Application for a non-material amendment following a grant of planning permission.

Planning application PF/22/1544 Erection of detached garage; conversion and extension of outbuilding to create annexe

PF/22/1544

Proposed Annex's elevation with Solar Panels

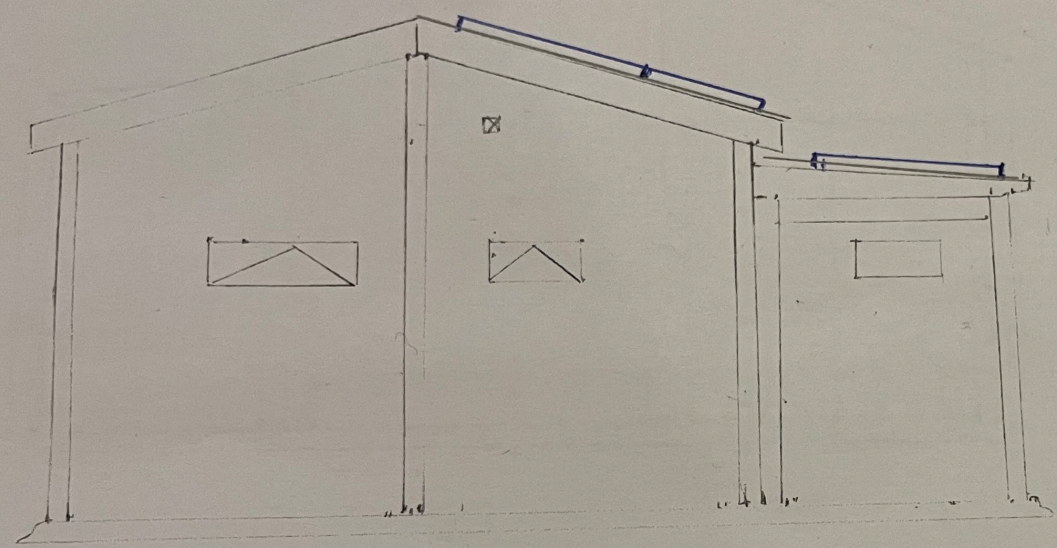
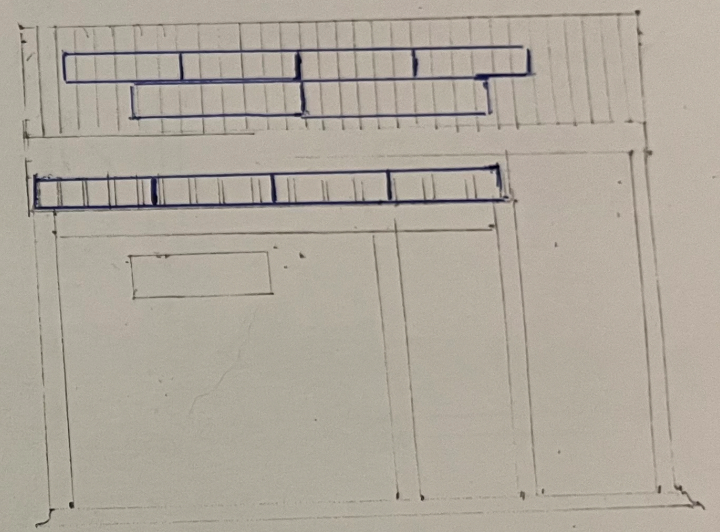
The no- material amendment sought we would like to add ten solar panels on the south elevation. The location is heavily screened from all other buildings and roads. We are taking great care in the positioning of these panels so that they will not draw attention to their physical impact.

The will be all situated on the south elivation flat to the roof in a 4 2 4 pattern  
4 at the top 2 on the side in the middle on the lower section of the main roof  
4 on the side building.
